KIRKLEES METROPOLITAN COUNCIL INVESTMENT & REGENERATION SERVICE

DELEGATED DECISION TO DETERMINE PLANNING APPLICATIONS

Reference No:	2022/62/90937/E
Site Address:	48, Woodburn Avenue, Earlsheaton, Dewsbury, WF12 8LJ
Description:	Erection of single storey rear extension and side dormer extension
Recommending Officer:	Elenya Jackson

Proposed Elevations

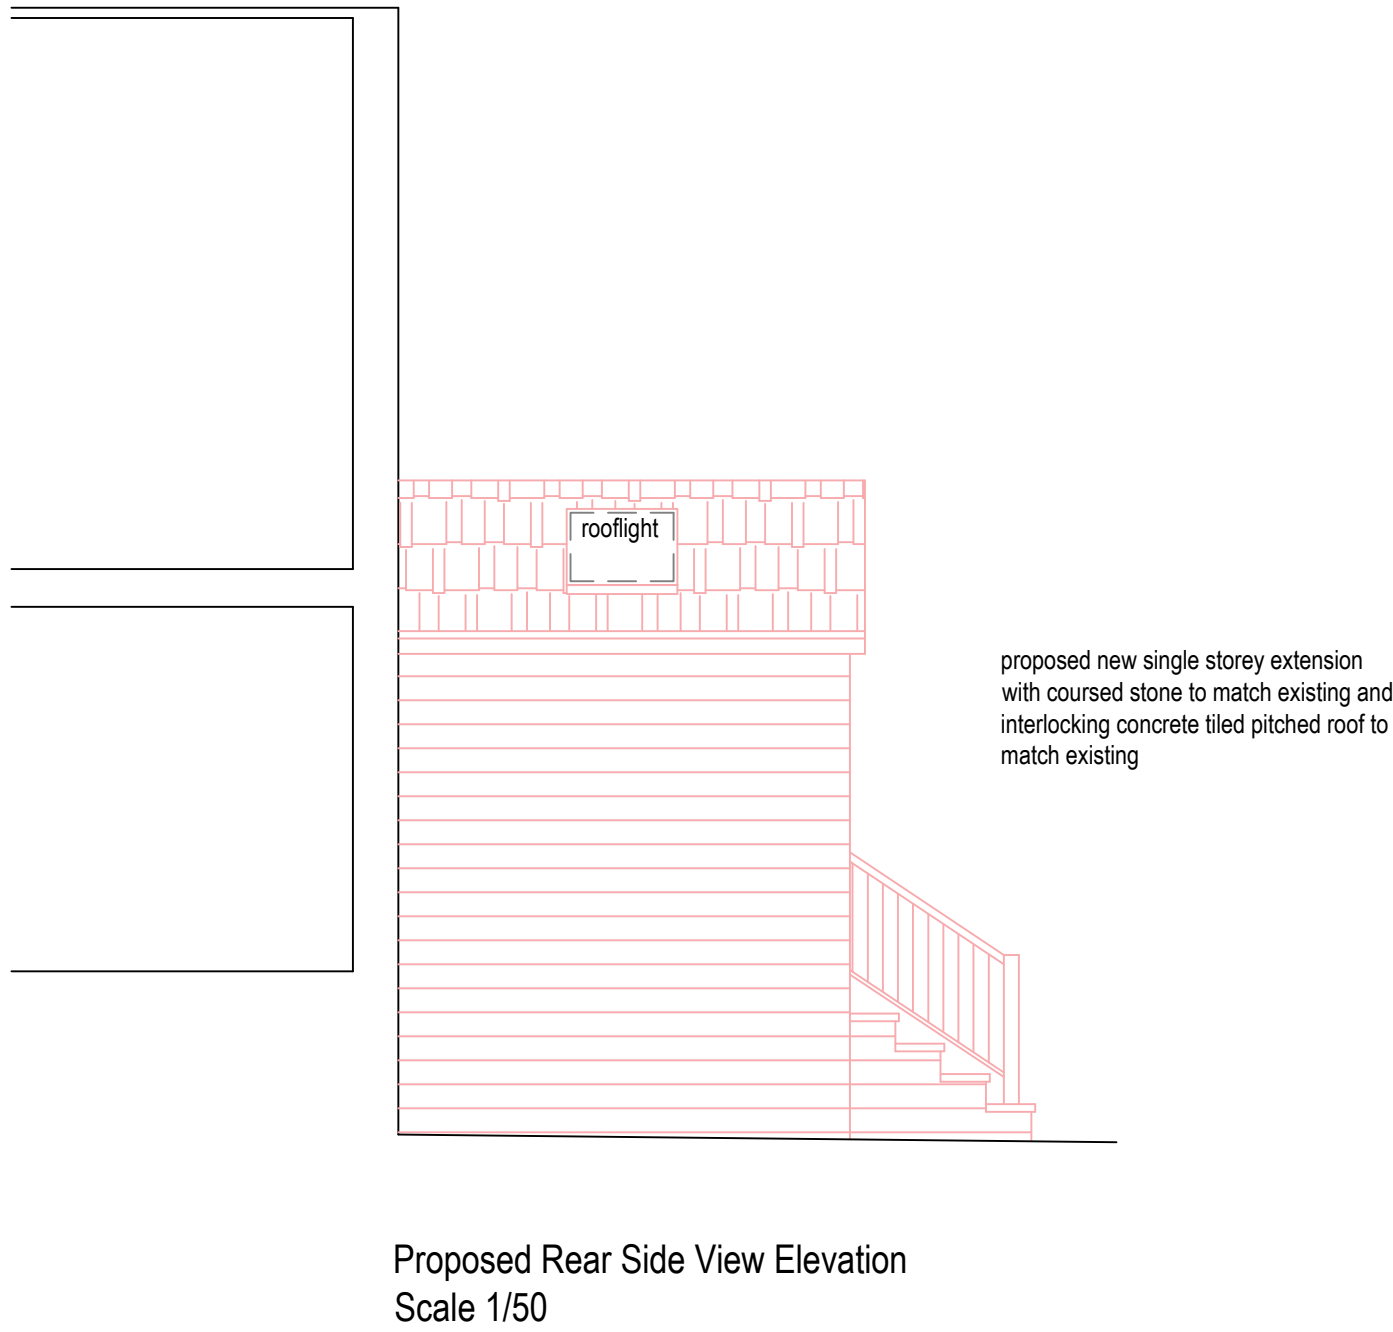
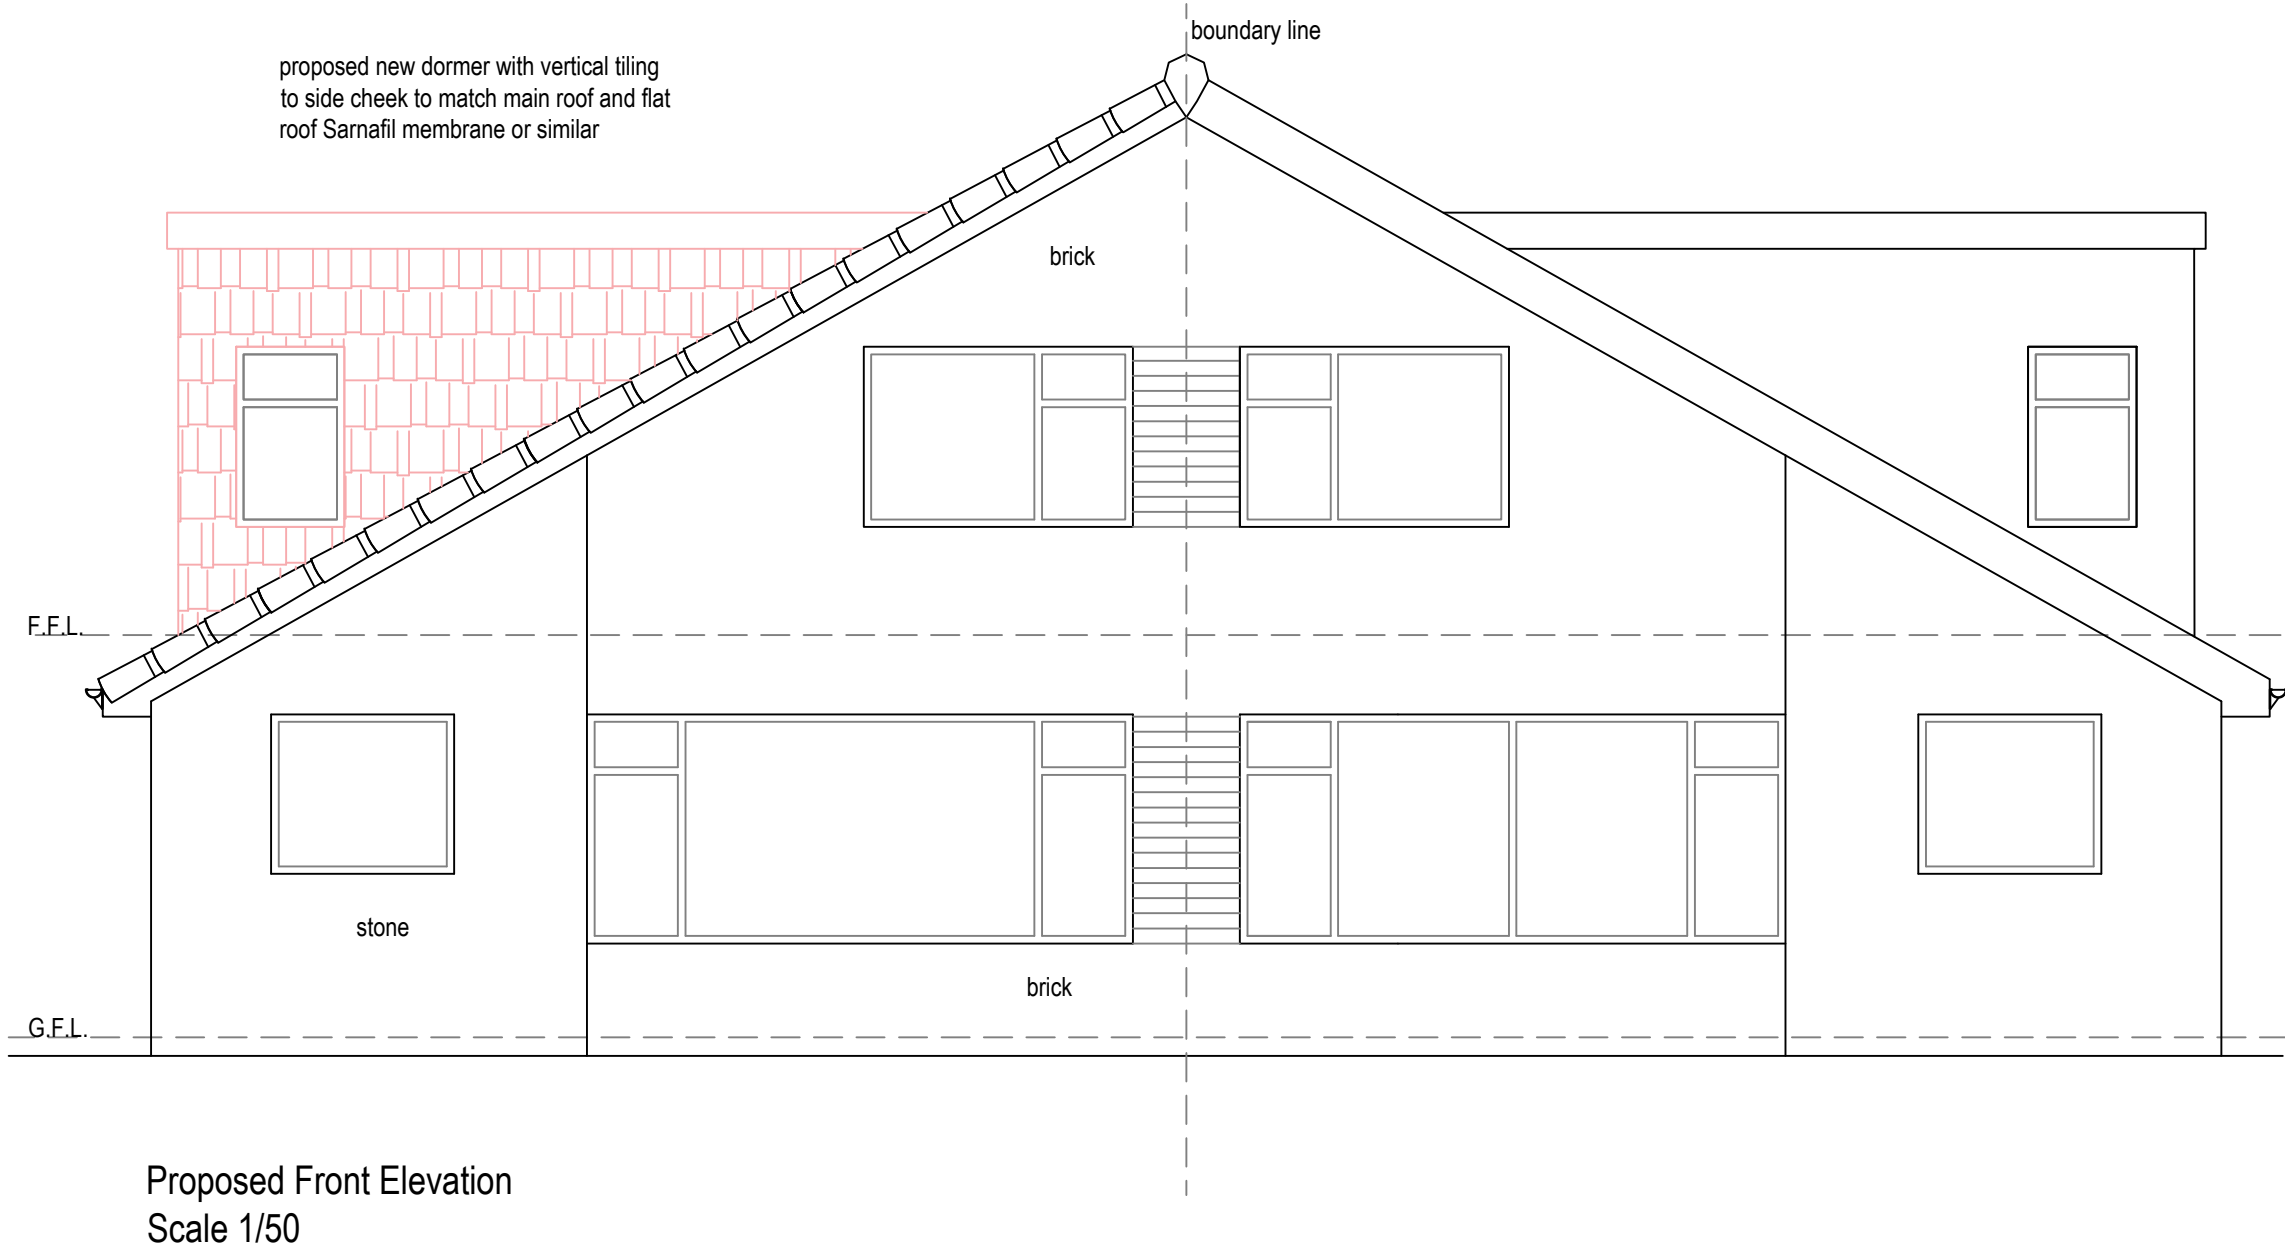
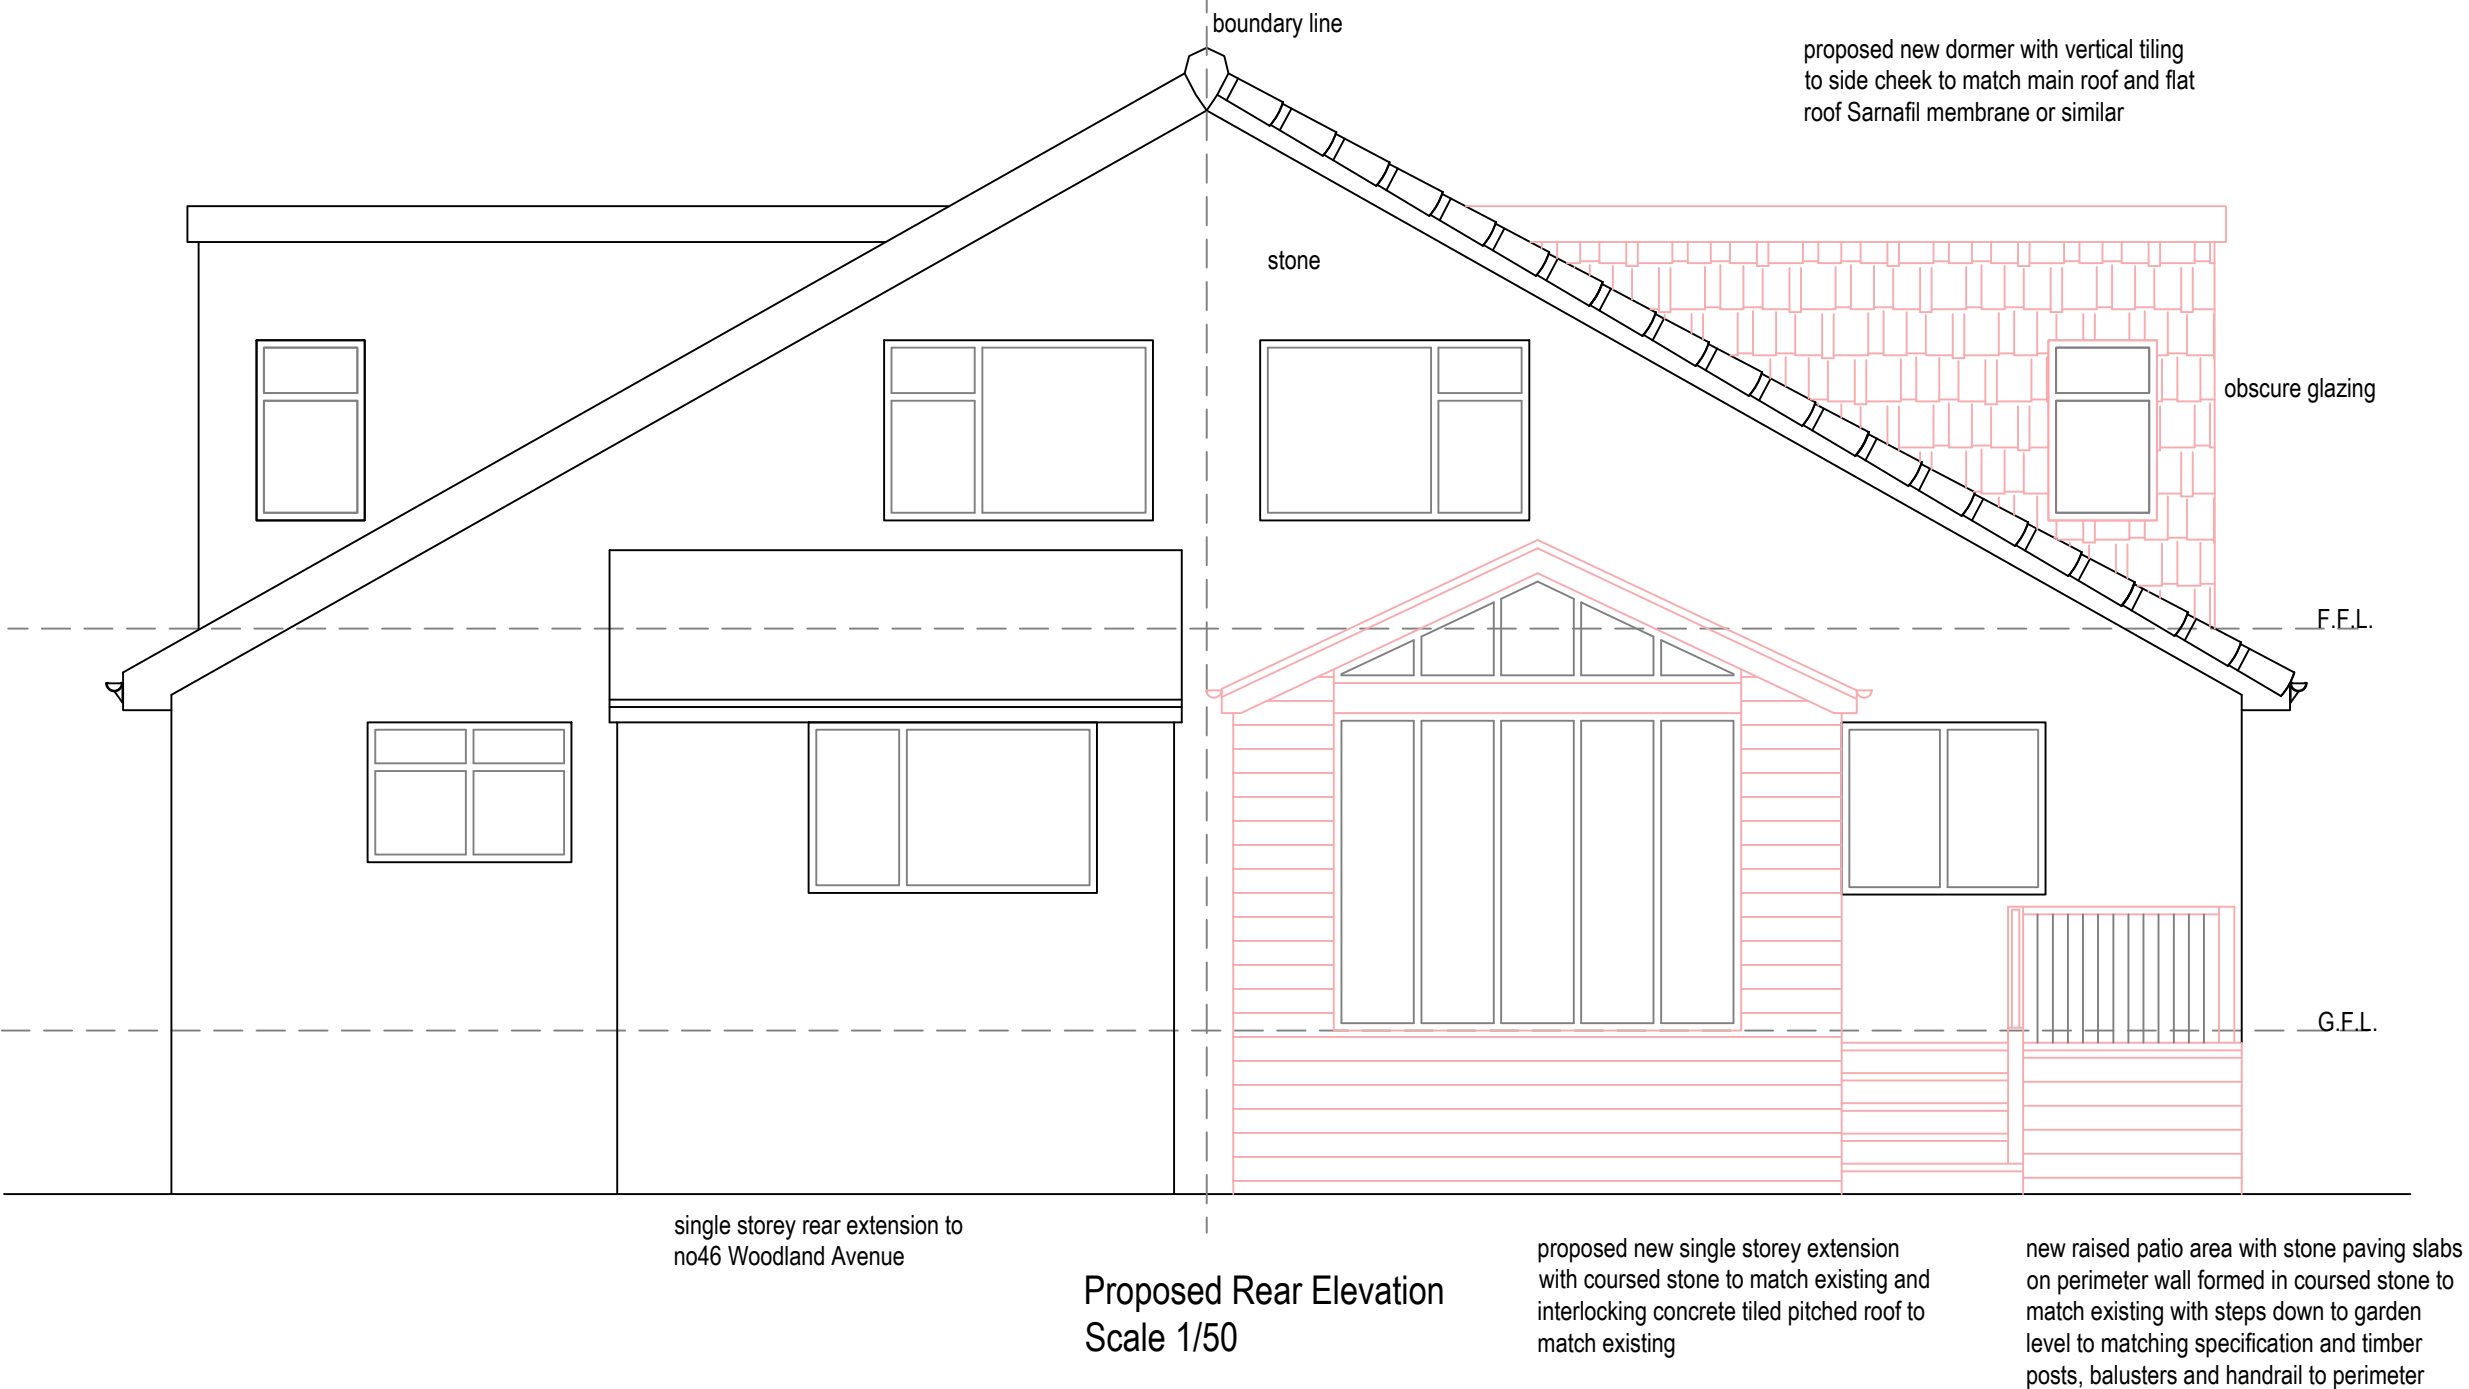
Overlooking: There is currently a fence between the gardens of the two properties and the driveway for both dwellings. The proposal would feature three side facing windows. One would be situated in the single storey rear extension and two would be situated in the dormer. It is considered that as the extension would be raised, the boundary treatment would not provide sufficient screening and a condition would be required for a 1.8m screen to be erected prior to first use to prevent the occupiers of no.48 being able to look into the private amenity space of no.50.

The dormer would feature two side facing windows, one of these would serve a bedroom. Due the design and positioning it is considered to mitigate any potential loss of privacy to adjoining occupants. It is not considered necessary to request this is obscurely glazed due to its height and distance from the neighbouring dwelling.

The bathroom window is shown to be obscurely glazed which is acceptable. Overshadowing/loss of light/overbearing: due to the scale of the proposal, there would be sufficient distance between the proposal and no.50 to not raise any significant issues regarding overshadowing/loss of light/overbearing.

4. The development shall not be occupied until the bathroom window in the north elevation of the dormer hereby approved have been obscure glazed. The obscure glazing shall thereafter be retained for the life of the development.

5. The development shall not be occupied until a 1.8m boundary screen has been erected on the northern elevation of the proposal. The screen shall thereafter be retained for the life of the development.
